Reference: PLANNING APPLICATION No. 16/01594/F

Proposed erection of 34 houses on land adjacent to Fewcott Road, Fritwell, by Cala Management Ltd.

Plot 33 - Plans & Elevations

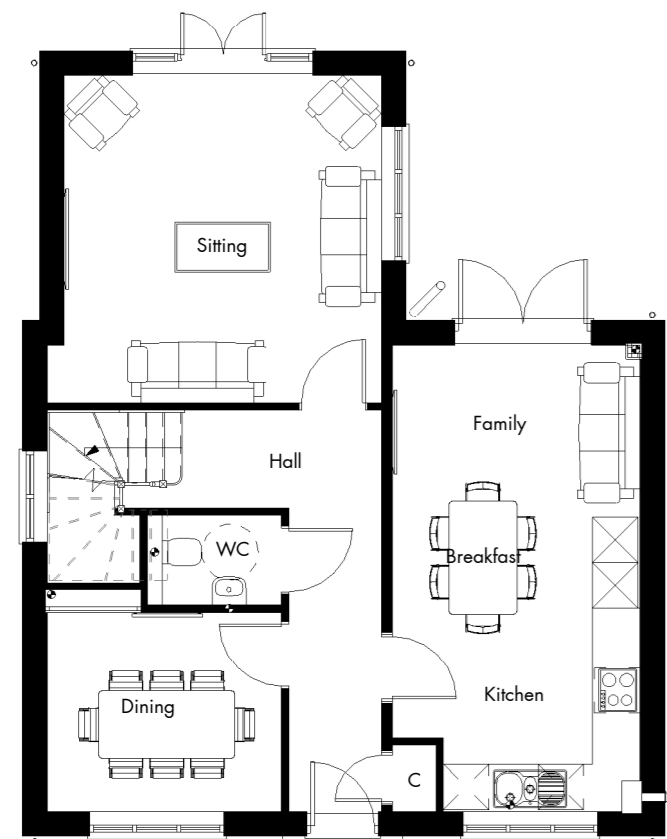
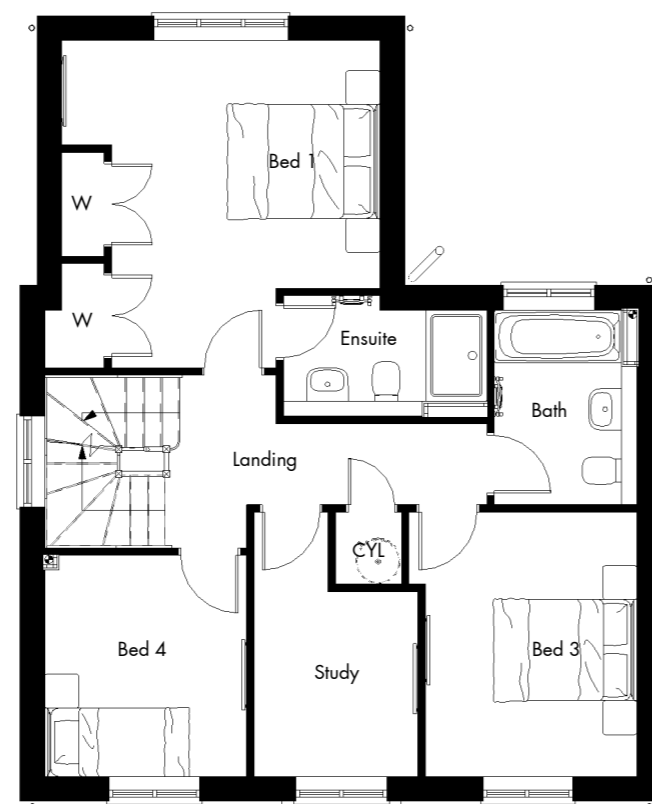
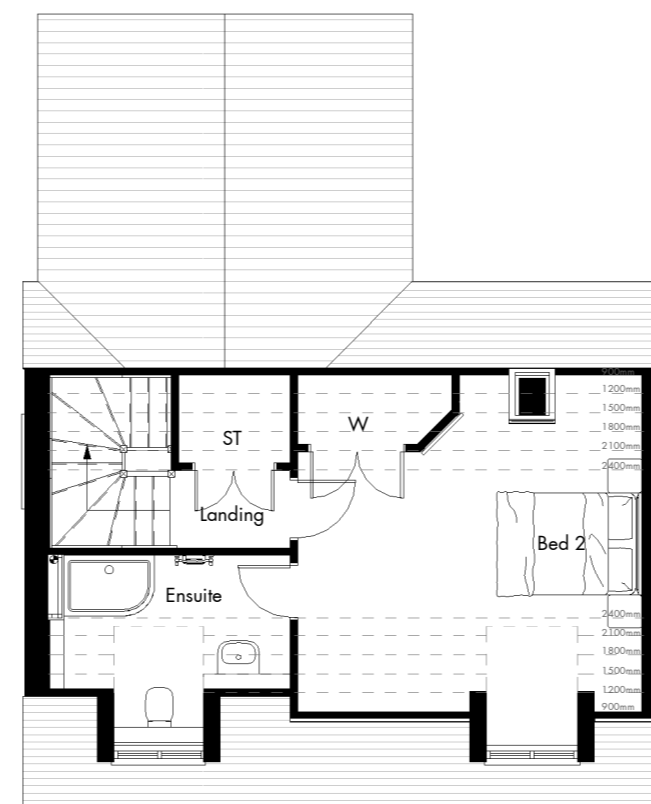
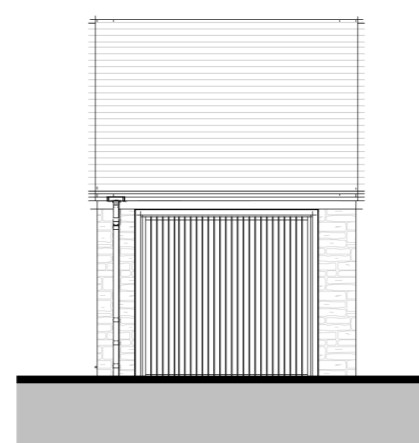
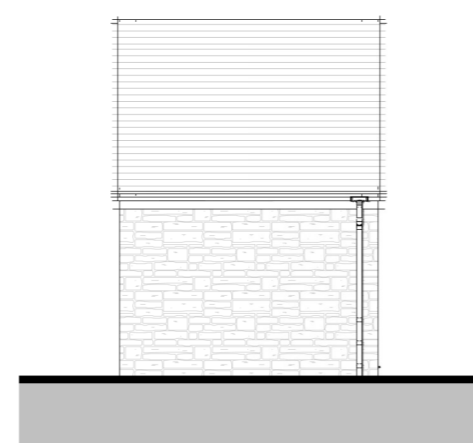
The design on the plans submitted by Cala Management Ltd are not in keeping with existing properties in Fritwell - the village has a very limited number of existing properties that are three storeys high and none of this type of property in the immediate locality of the proposed development site.
